DEVELOPMENT FACILITATION TEAM

Planning - Case Comments

Project Number: PR-2024-010951

Project Name: West Mesa Ridge

sheet no:  
**TCL2.1**

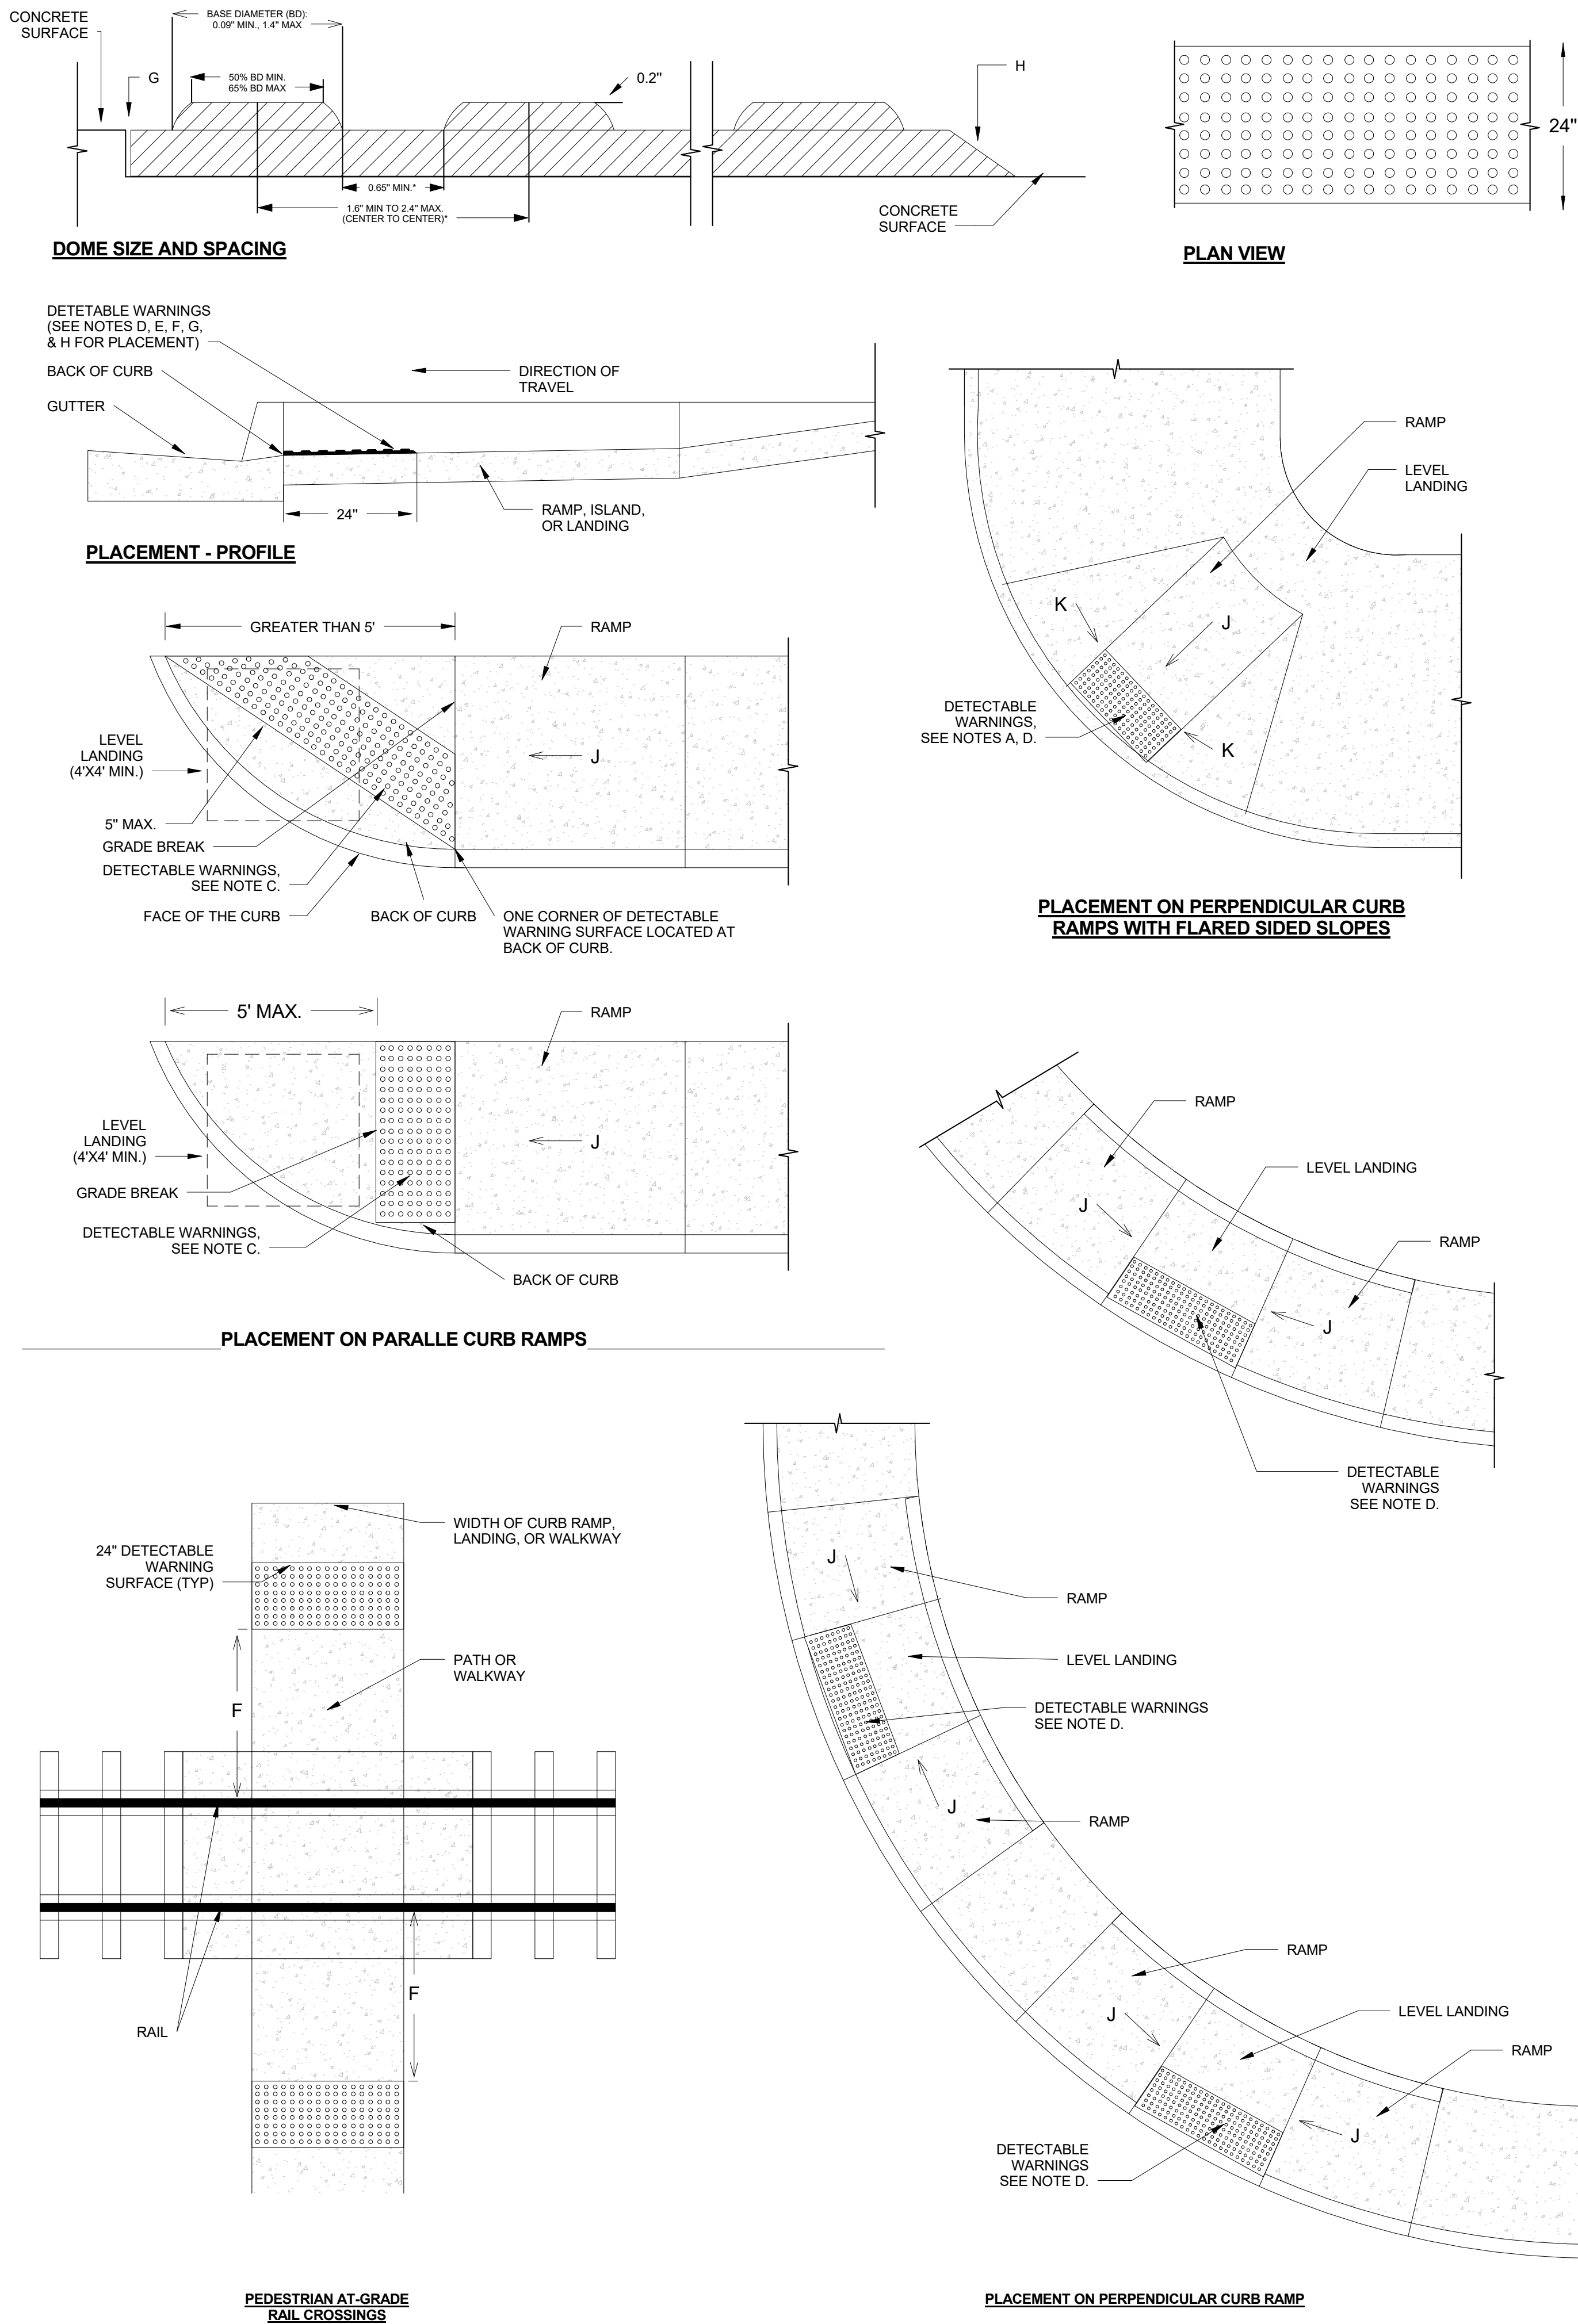
Motorcycle parking spaces are shown on the conceptual TCL as both keyed note 33 and keyed note 35. Please clear this up using only one keyed note to annotate motor cycle parking on future submissions.

Bicycle parking is shown on keyed note 13 as (32 bike rack arches (64 spaces)). Planning staff counts 8 instances where this note appears on the TCL. Please clear up the phrasing to show how many bike racks will be installed per keyed note.
